Ribble Valley Borough Council  
Housing & Development Control

Application no: **3/2022/0678**

Address: **Chipping Farm Shop Wilsden Garstang Road Chipping PR3 2QH**

Proposal: **To erect (partially retrospective) two timber frame gazebos to the front (roadside) of Chipping Farm Shop. The gazebos include perspex windows to the roadside and end furthest from the car park area. The gazebos are to provide a covered seating area for the consumption of food and drink bought on site.**

SITE PLAN SCALE 1:500

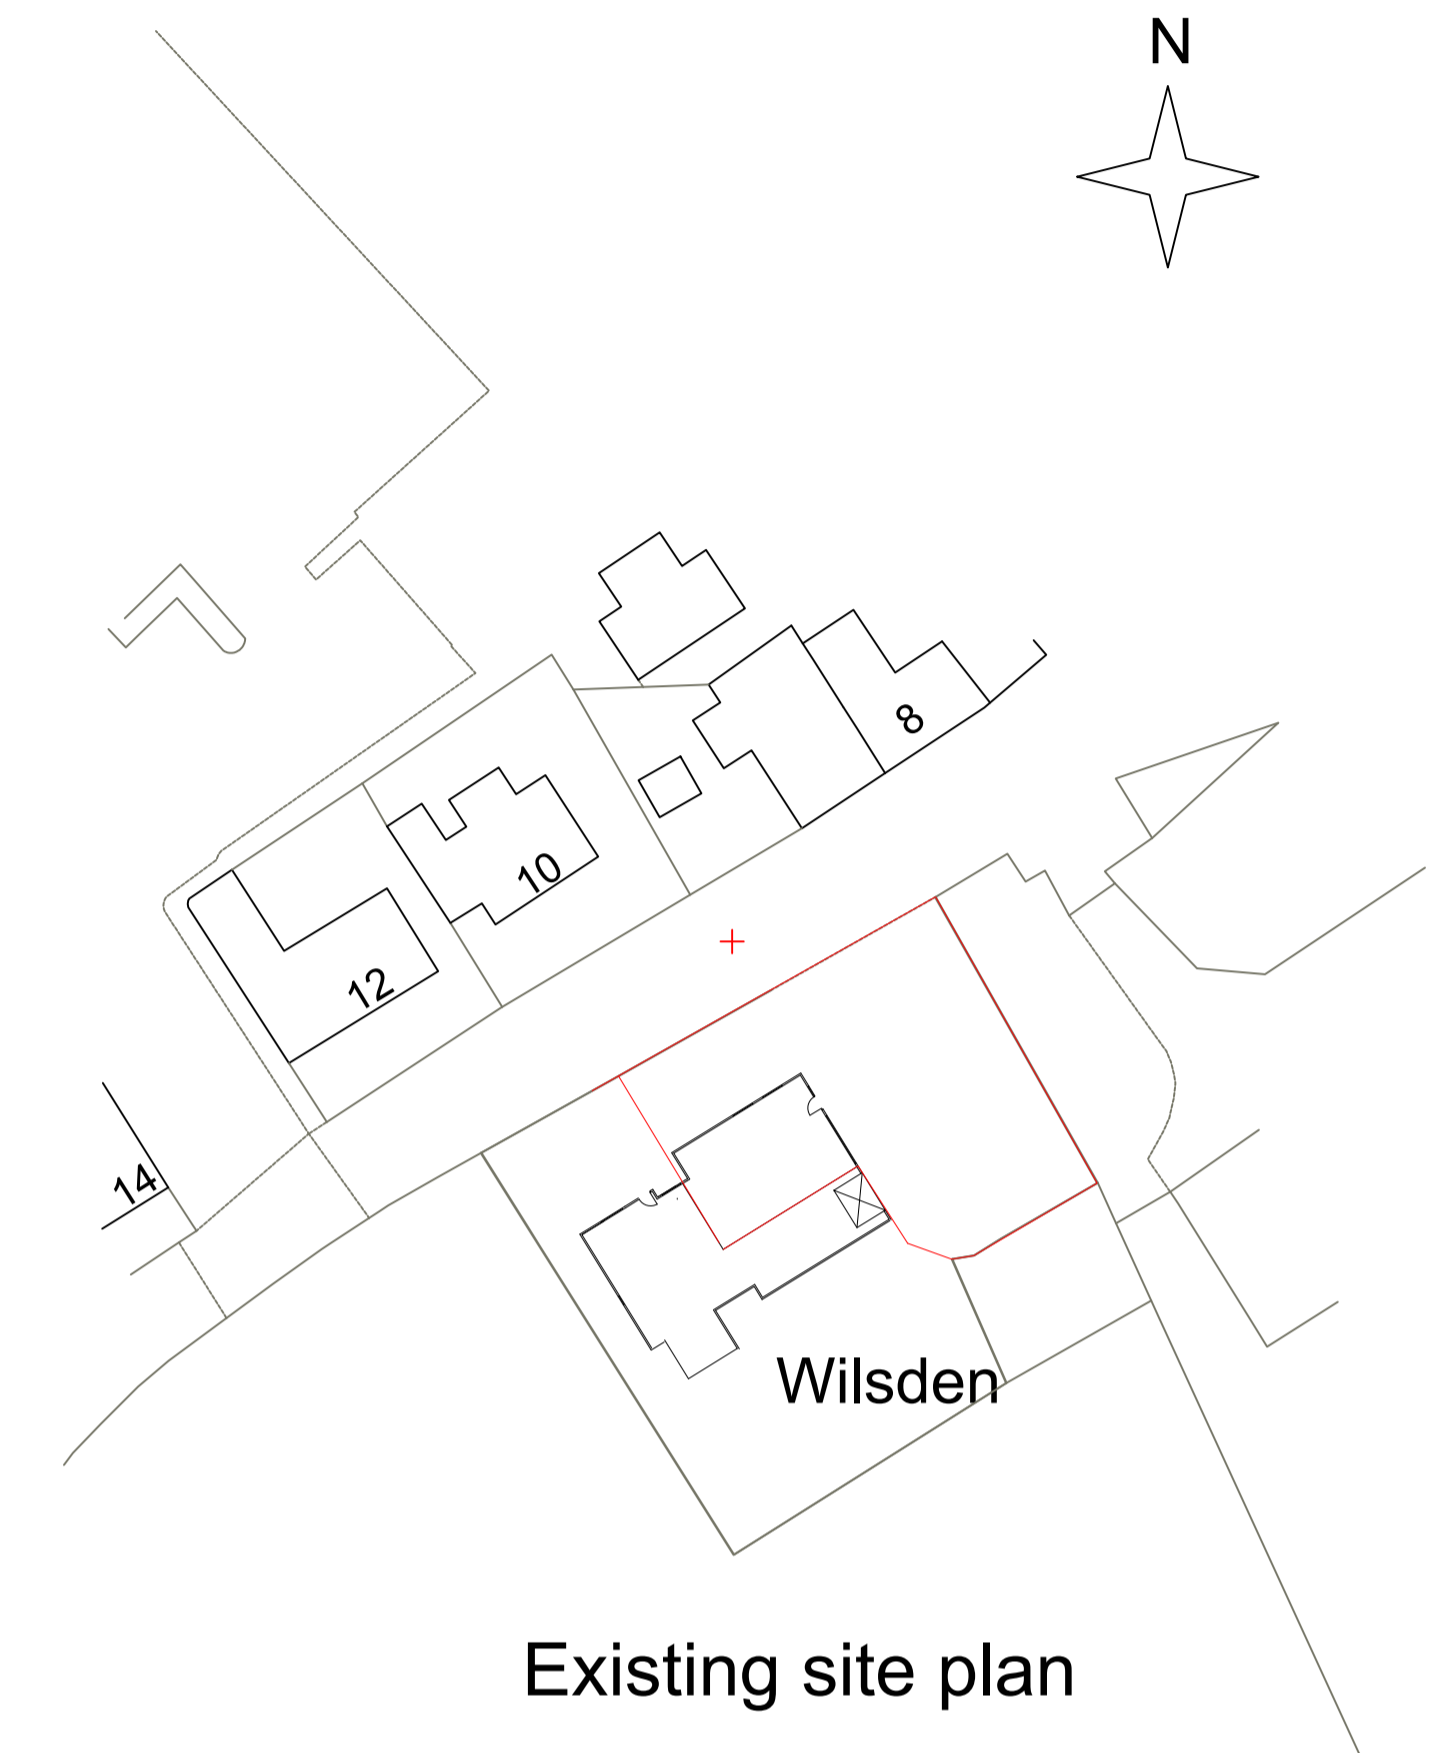
The LHA have reviewed ML drawing number LM/AB/5010 and are aware that the site can provide minimum visibility splays of 2.4m x 43m in both directions, with the splays being located out of the gazebos. Therefore, the LHA have no objection to the proposal.

The LHA have reviewed ML drawing number LM/AB/5010 and are aware that 5 car parking spaces are provided at the site. While the LHA are aware that no information has been provided regarding the internal floor area of the canopies, the LHA are aware that the canopies are retrospective and there has been no parking complaints regarding the development and there is a public car park across the road. Therefore, with this in mind the LHA have no objection to the proposal.

1. No part of the development hereby permitted shall be occupied until such time as vehicular visibility splays of 2.4 metres by 43 metres have been provided at the site access. These shall thereafter be permanently maintained with nothing within those splays higher than 1 metres above the level of the adjacent footway/verge/highway.

2. The development hereby permitted shall not be occupied until such time as the parking and turning facilities have been implemented in accordance with ML drawing number LM/AB/5010. Thereafter the onsite parking provision shall be so maintained in perpetuity.
